Address: Shiraz, 142 Upperthong Lane Holmfirth Hd9 3uz

Application number: 2022/93510	
What is the application for?:	Erection of detached dwelling with intergral garage
Address of the site or building:	Shiraz, 142, Upperthong Lane, Upperthong, Holmfirth, HD9 3UZ
Postcode:	HD9 3UZ

Type of comment: An objection	
Do you wish your comments to be published on the website anonymously?	No
I wish to comment on the planning application 2022/62/93510/w. I am an immediate neighbour and live st Hilltop which is south-east of the site. I bear no ill will towards the applicants who have been my neighbours for about 15 years. I admire their ambition and i do not wish to thwart it. That said i must look after my own interests and protect the benefits that i currently have. I have lived in my current house for 37 years. I am now in my late 70s and would like to think that i will be able to live at Hilltop in relative peace and quiet. On this basis i would like to make the following points. 1. Overlooking. Though the design statement says that the proposals are to replace the existing property on a very similar footprint, the rear half of the house is nearly doubled! This increase in width is towa

Scale (at A1)	Date
AS SHOWN	28.04.2022
Drwg. no.	Rev.
109-22-PL02	E

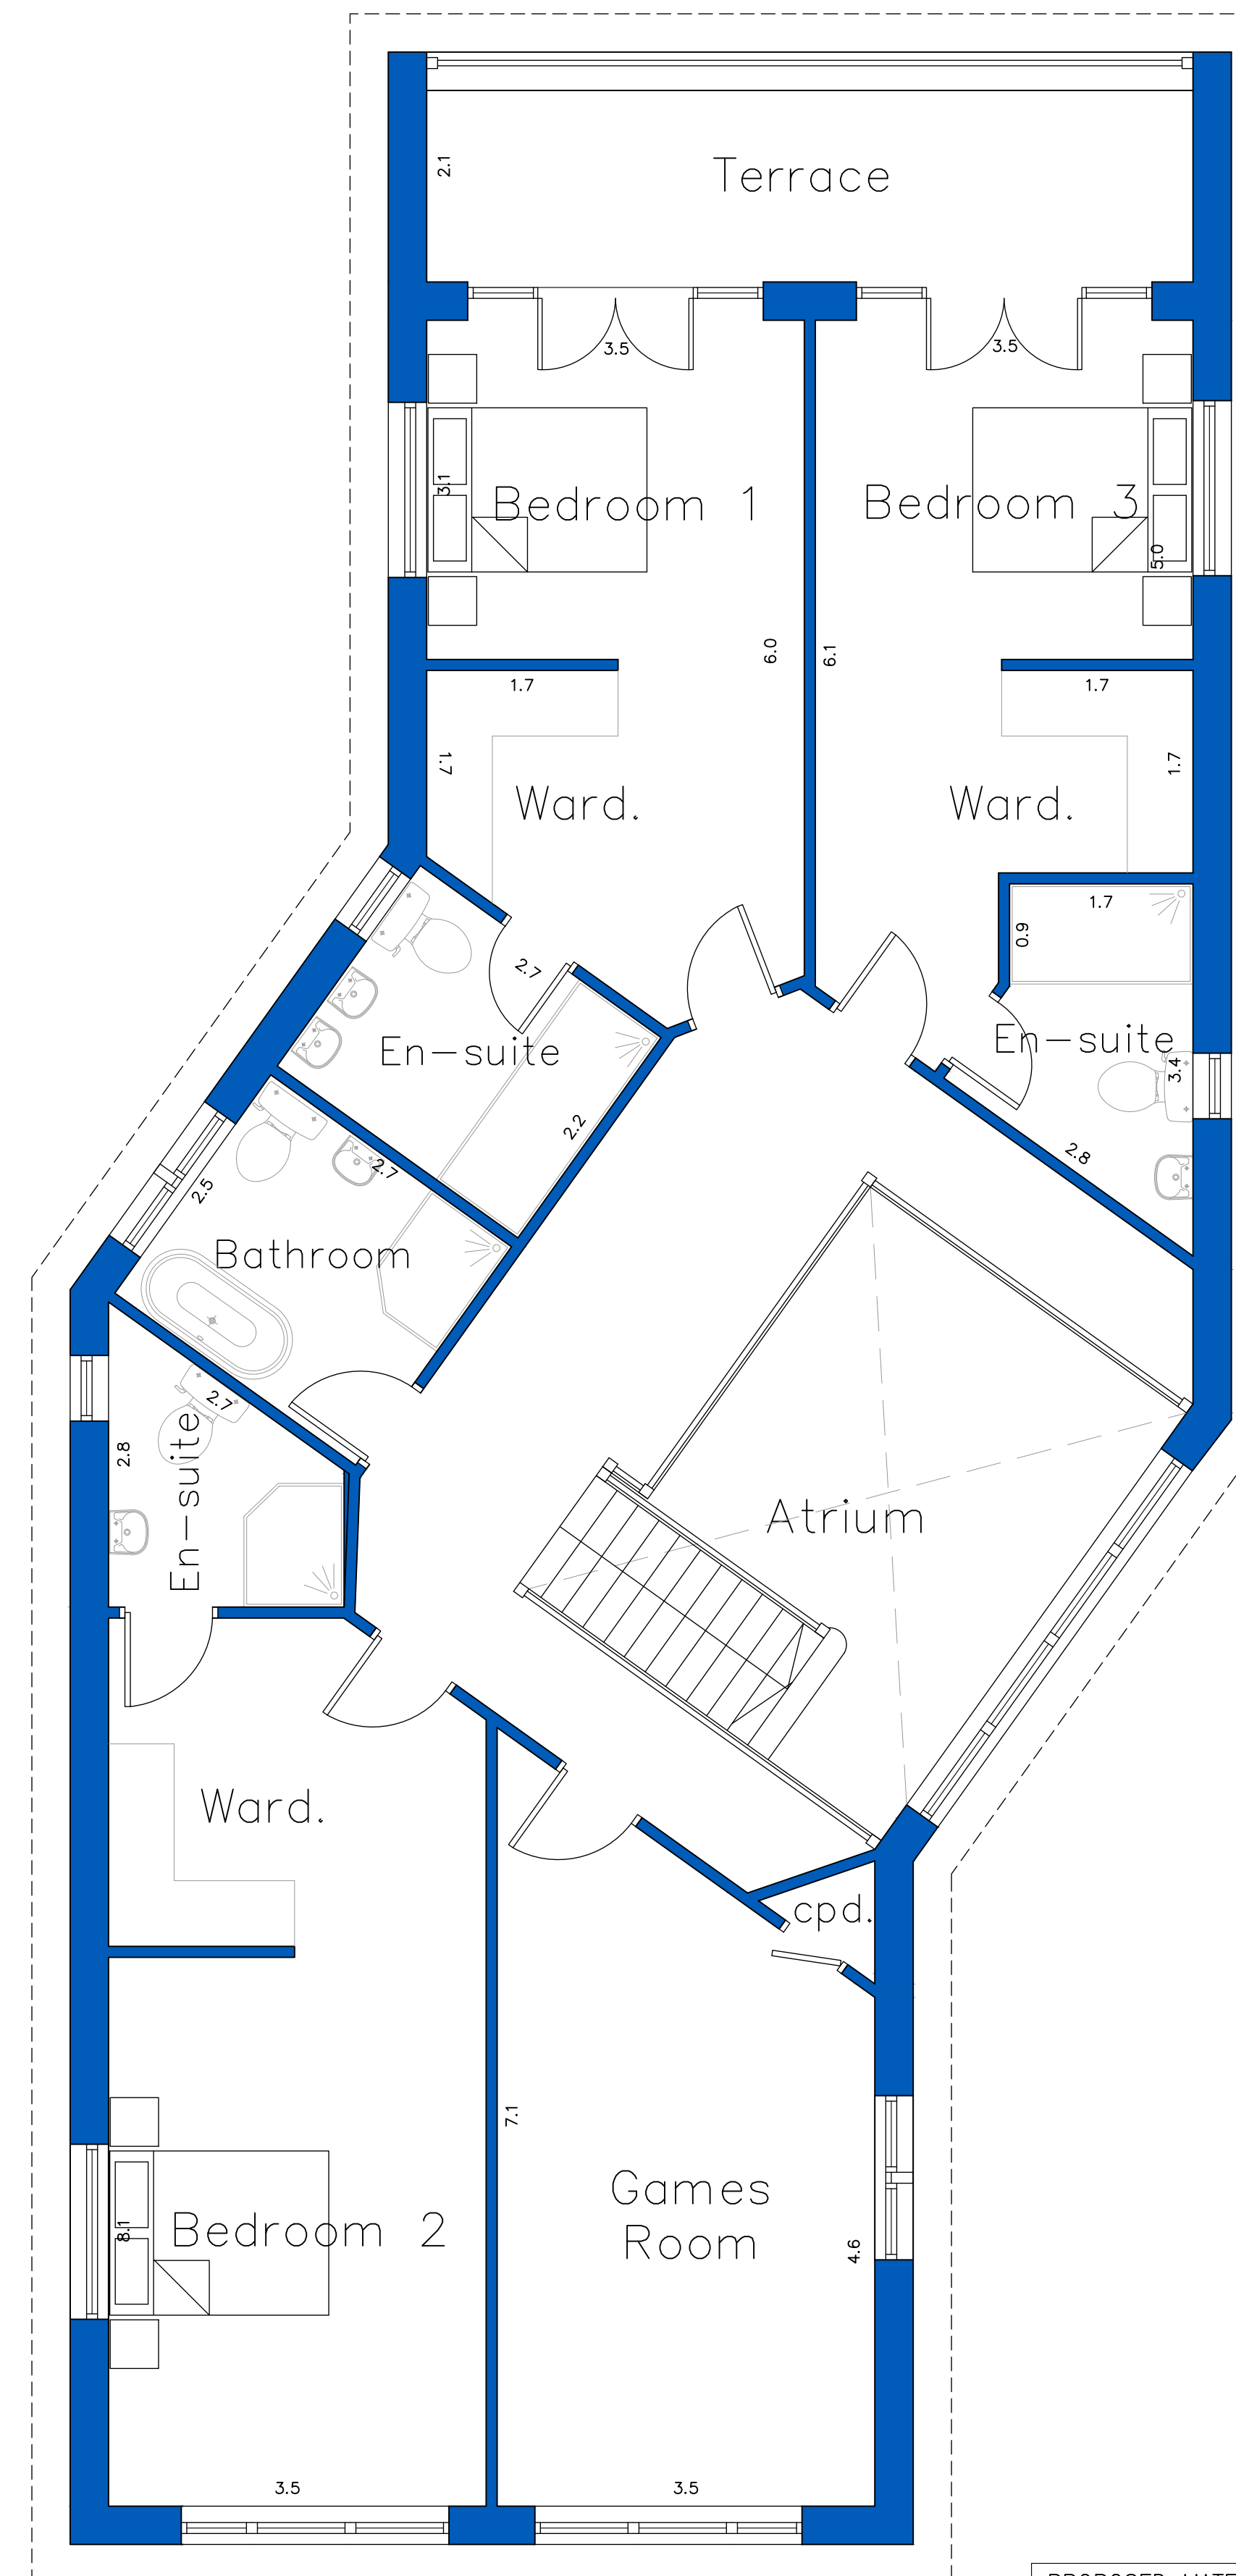
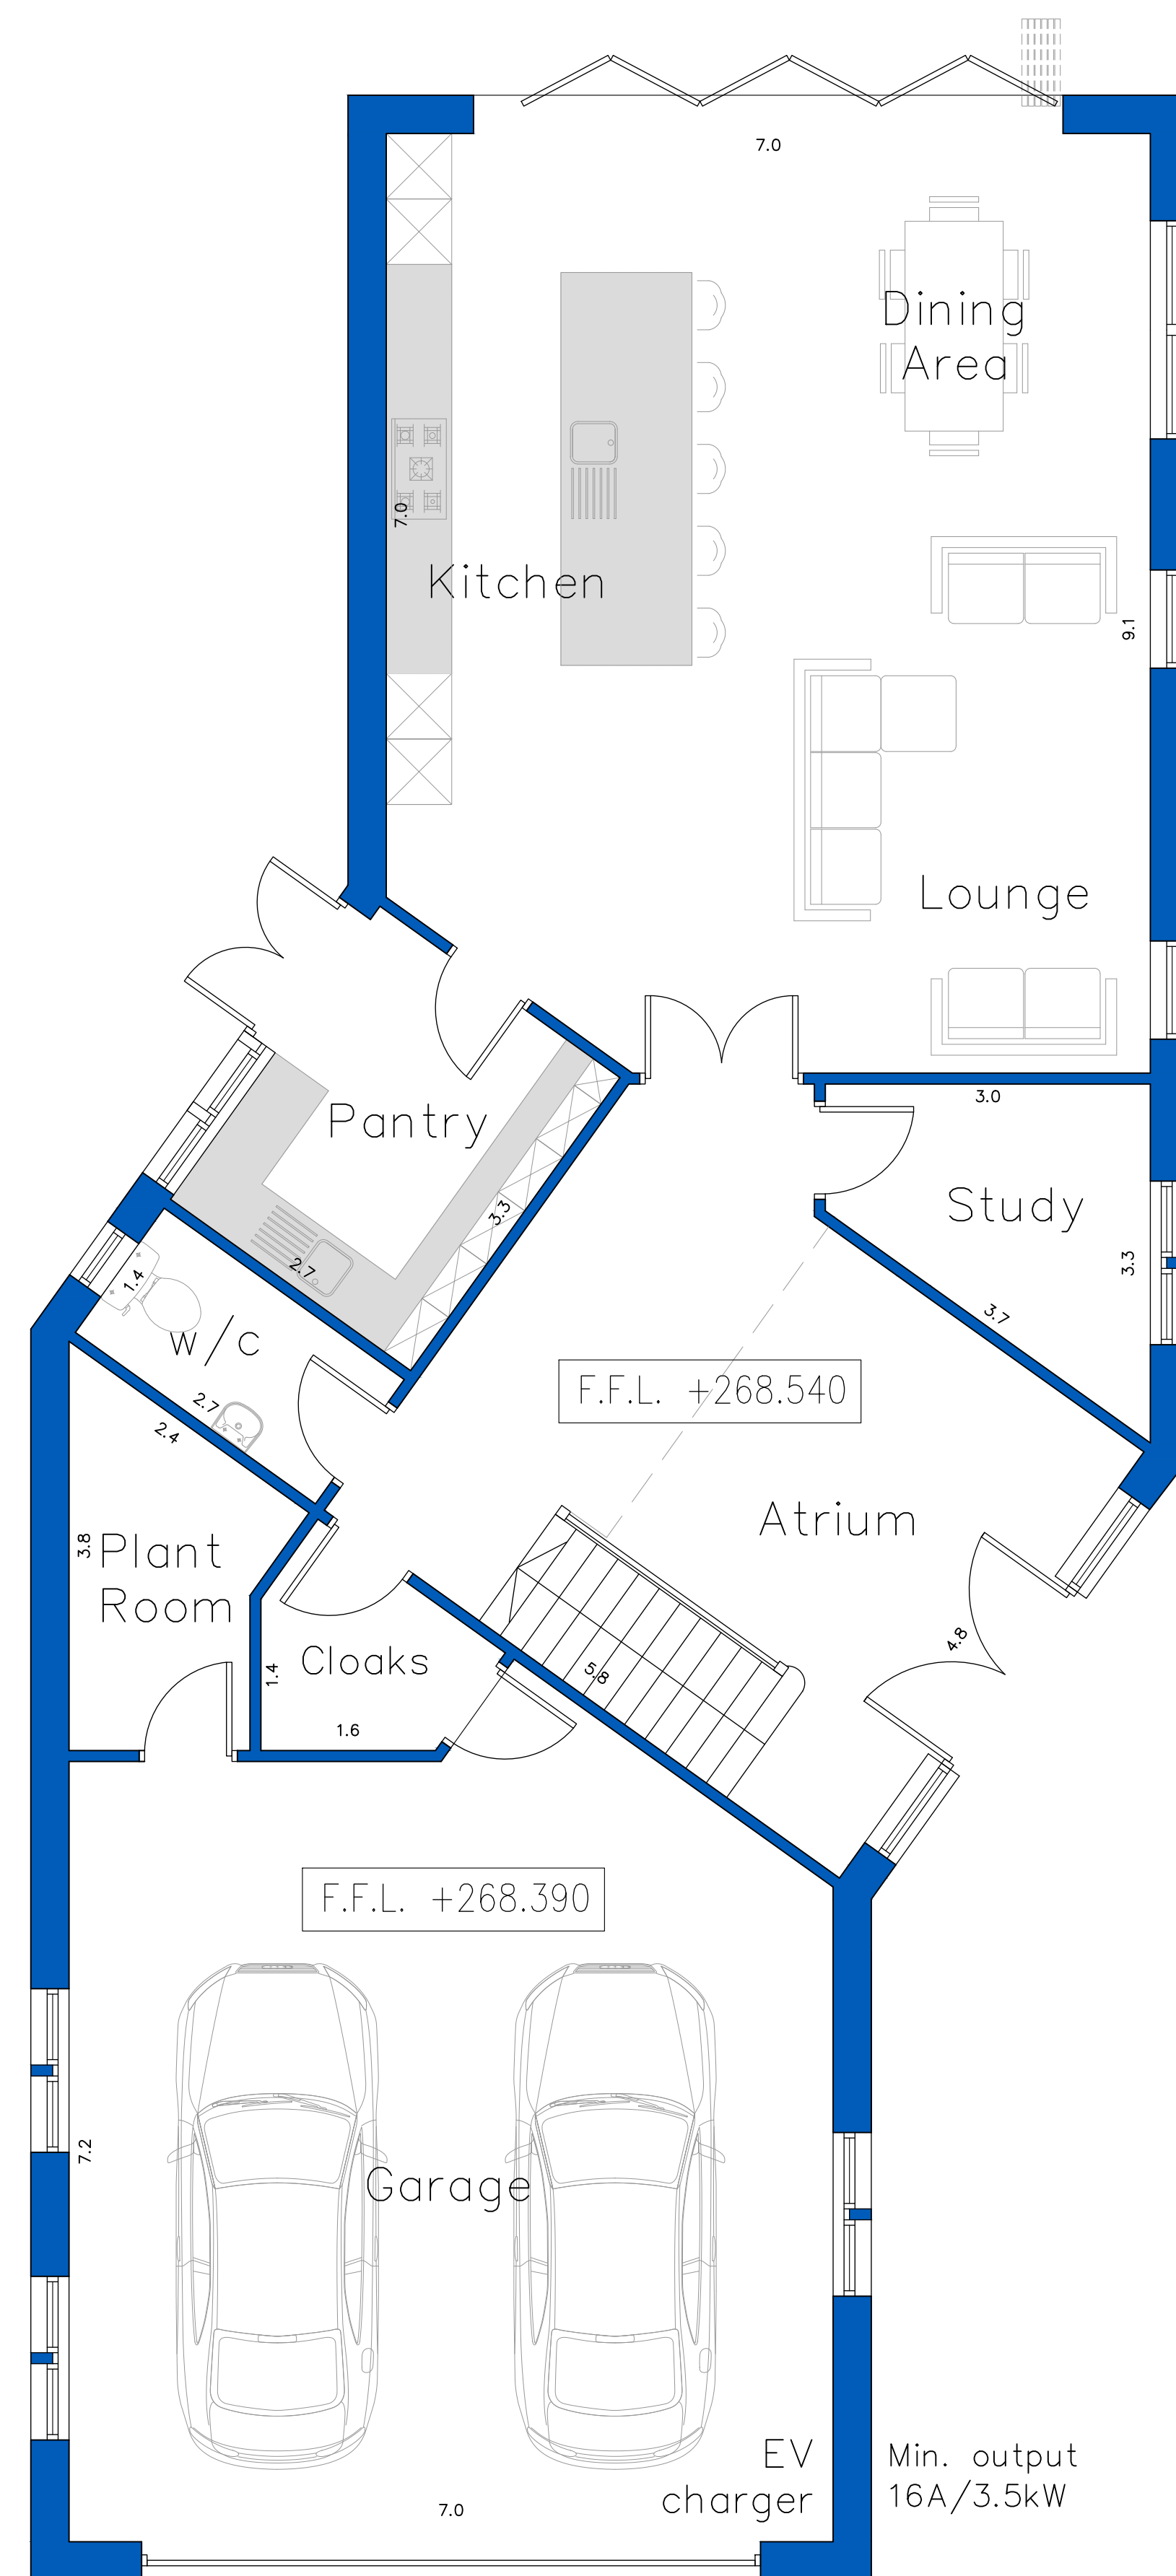
overlooked by the fully glazed atrium. An atrium may, or may not be categorised as habitable however from the proposed plans it appears that someone standing on the left-hand side of the upper gallery could look straight into my gable end window (109-22-PL01 and PL02).
